<b>Item No.</b>	<b>Report of the Head of Development Management and Building Control</b>	
<b>Address:</b>	SPRINGWELL FACTORY SPRINGWELL LANE HAREFIELD	
<b>Development:</b>	Change of use from Industrial (Class B2) to a Scrap Metal Yard (Sui Generis) (Retrospective application)	
<b>LBH Ref Nos:</b>	<b>35376/APP/2024/282</b>	
<b>Drawing Nos:</b>	100 P2 101 P2 Heritage Statement	
<b>Date Plans received:</b>	28-02-24	<b>Date(s) of Amendments(s):</b>
<b>Date Application valid</b>	28-02-24

**REFUSAL** for the following reasons:

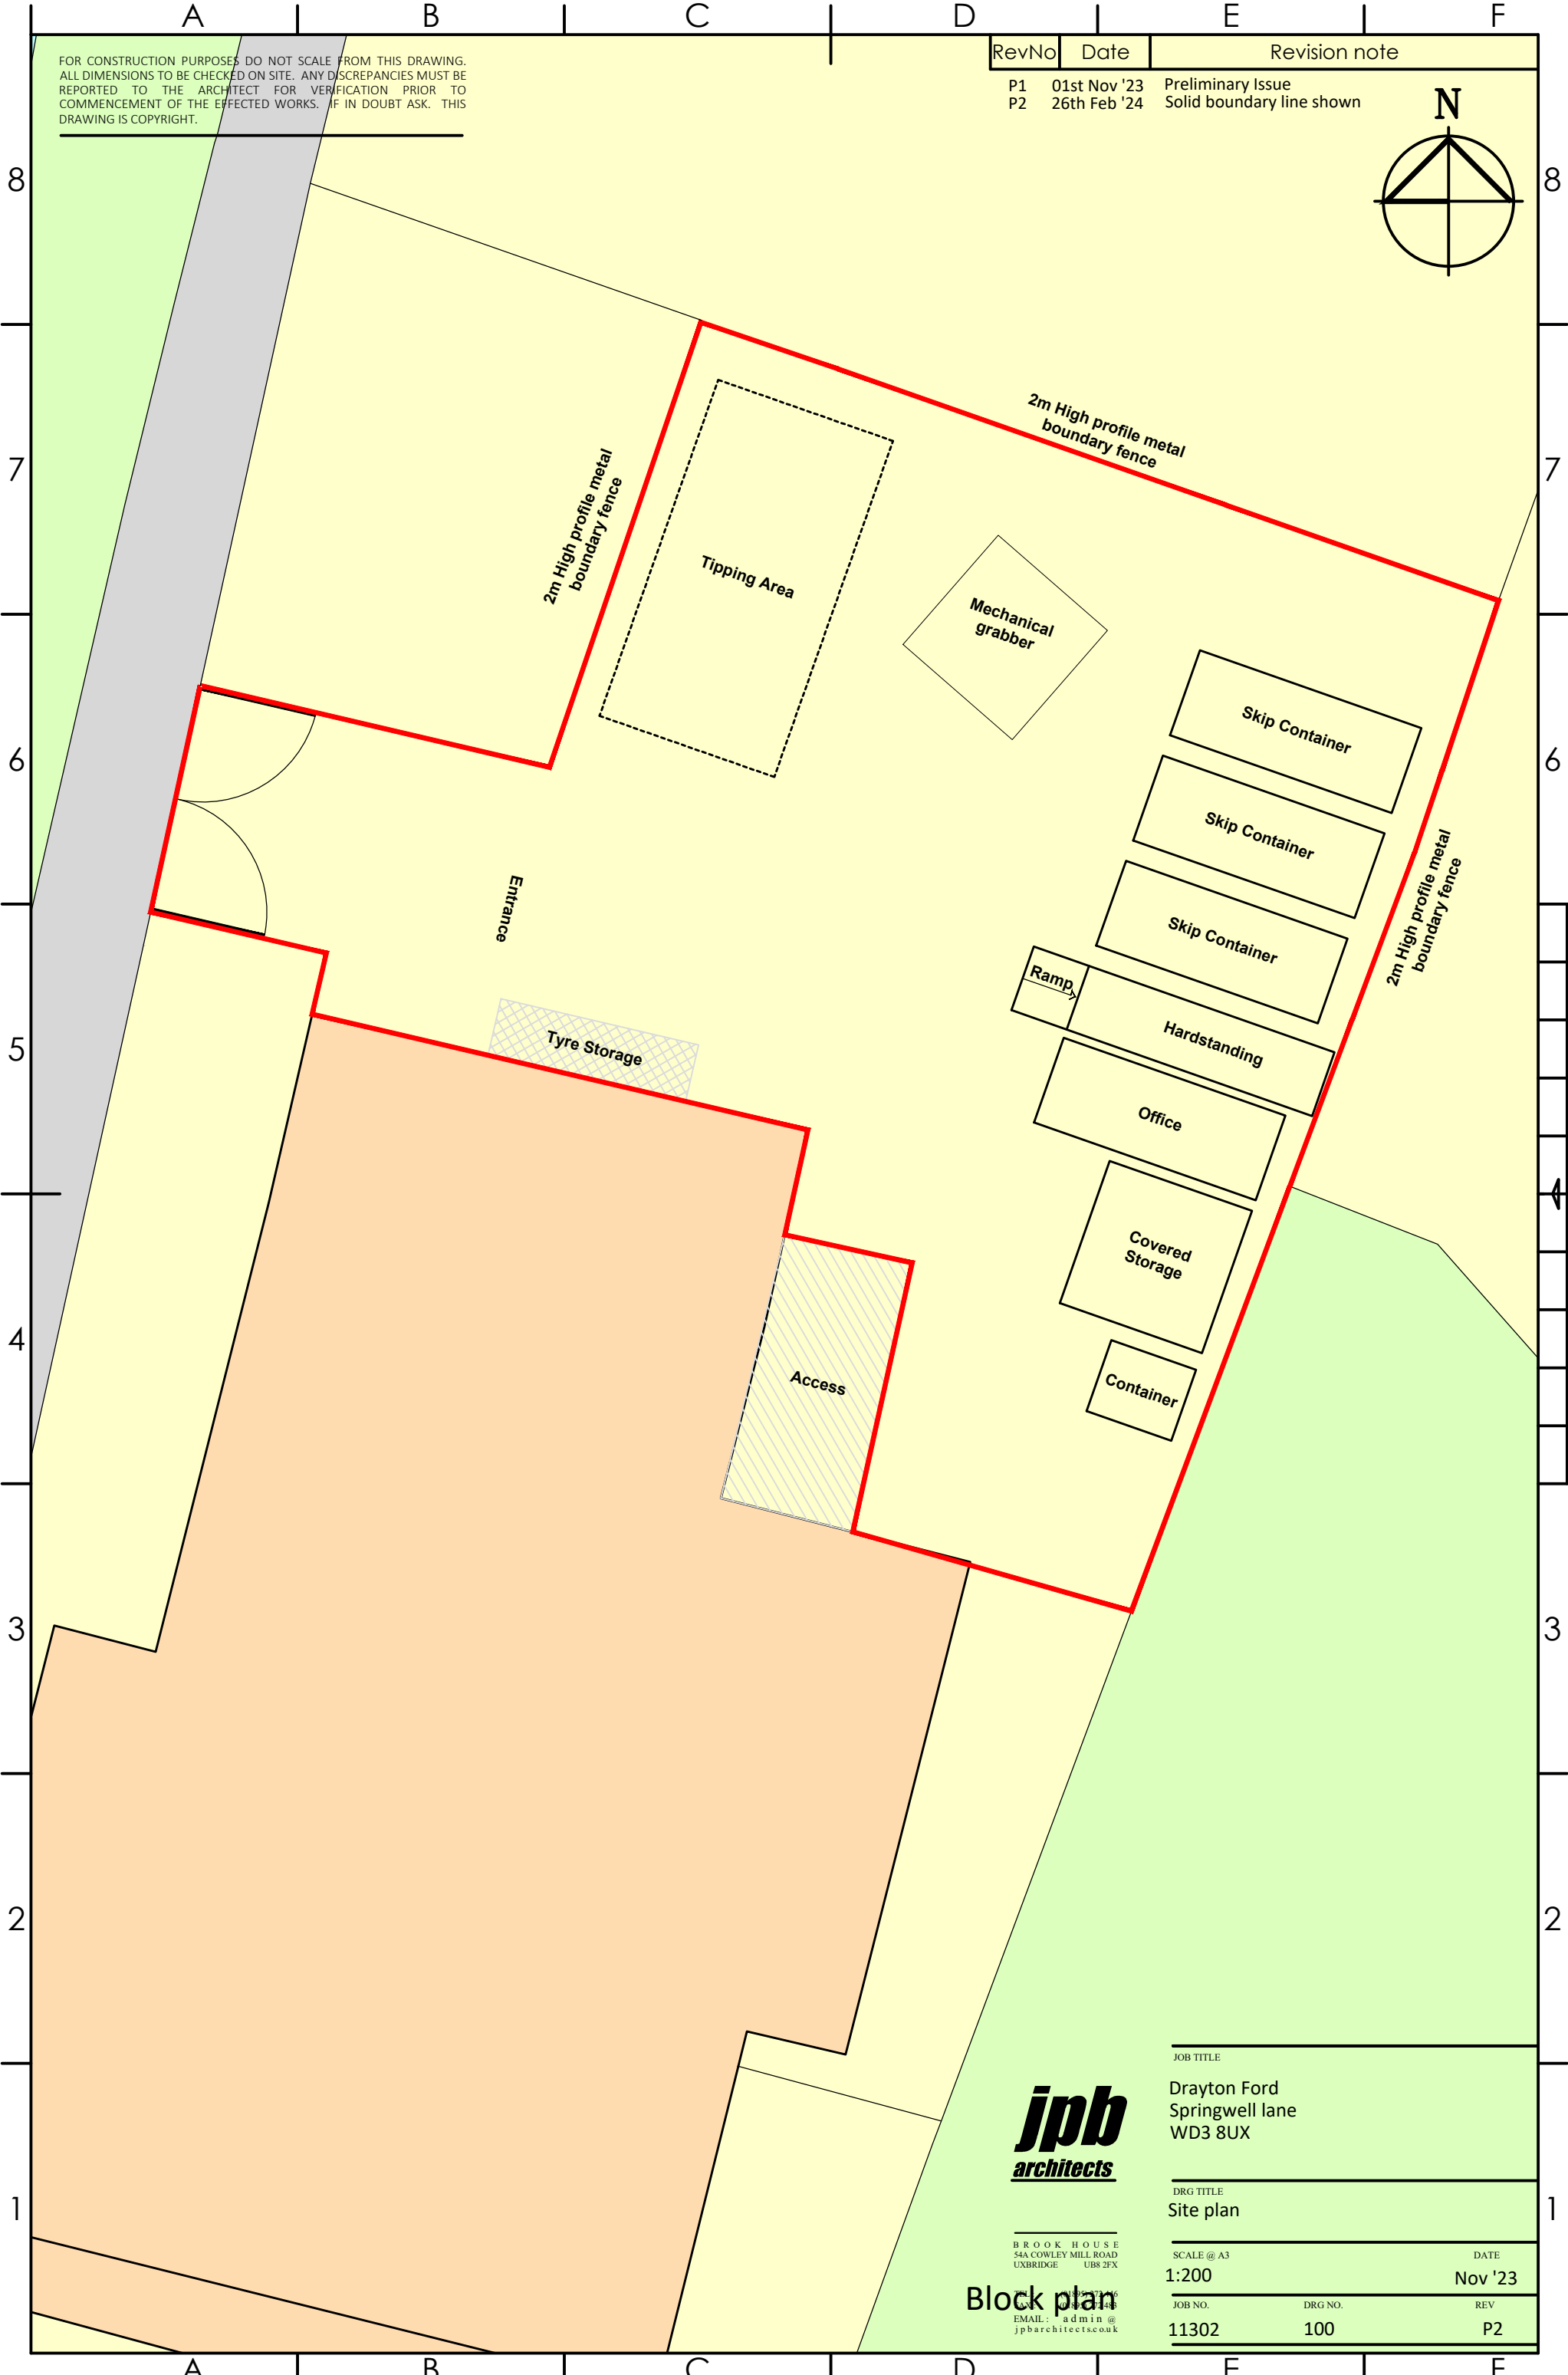
The proposed Site Plan indicates that the site will accommodate a:

- Tipping area;
- Mechanical grabber;
- 3 no. shipping containers;
- Office;

- Covered storage;
- Container;
- Tyre storage

The application lacks detailed information regarding elevations and floor plans. Nevertheless, the proposed use of the site as a scrap metal yard does not align with the exceptions outlined in Paragraph 154 of the NPPF (2023). Although the site was originally part of a larger Class B2 area, historic aerial imagery reveals that this specific section has been used for car storage. The proposed addition of shipping containers, metal storage, and office and the operational nature of a scrap metal yard would intensify the site usage.

The inherent nature of a scrap metal yard implies a significant accumulation of scrap metal at any given time, which would materially impact the openness of the Green Belt. Additionally, the proposal includes the erection a 2m high profile metal fence surrounding the site boundary. The proposal would significantly alter the landscape, making it noticeably from the surrounding area and changing the site's character. The construction of an office and siting of shipping containers would introduce new built forms into an undeveloped part of the site. This, combined with the site's intensified use, would further diminish the openness of the Green Belt.
